MONUMENT SMALL ENGINE STORAGE

SITE DEVELOPMENT PLAN

Markup Summary

MONUMENT SMALL ENGINE STORAGE SITE DEVELOPMENT PLAN

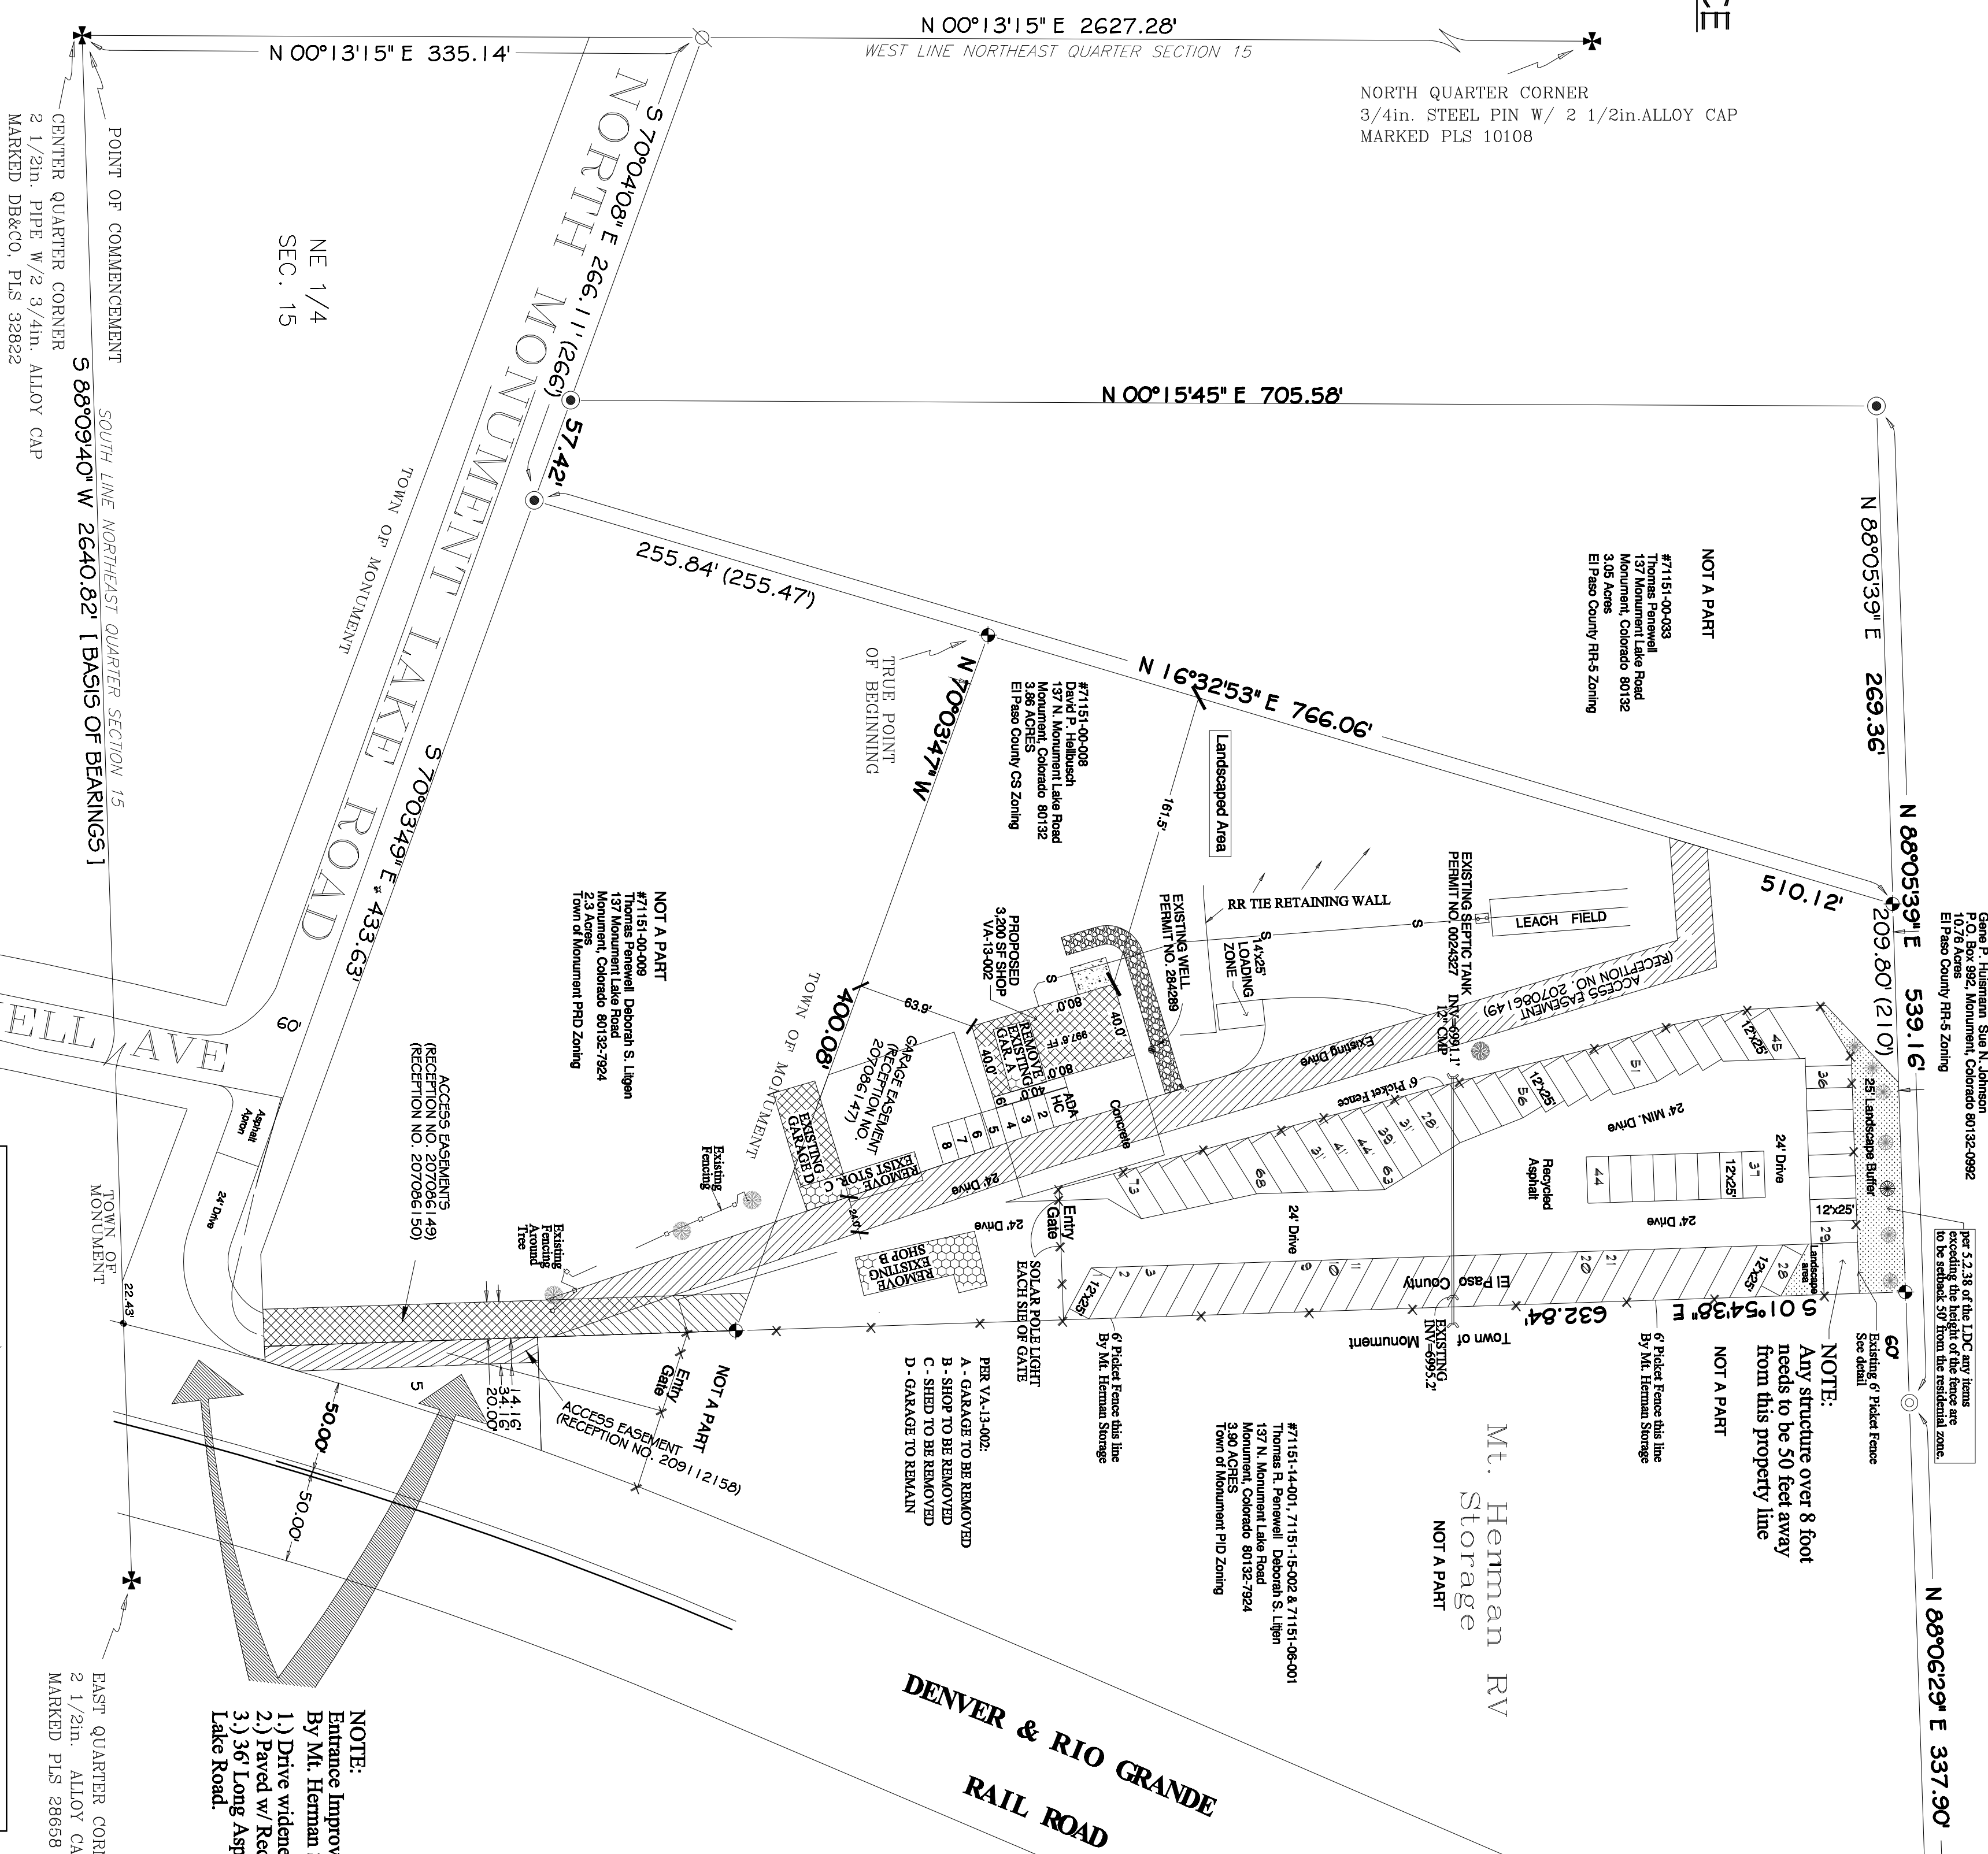
This garage is across the property boundary, it cannot be approved as such. Mark it as to be removed.
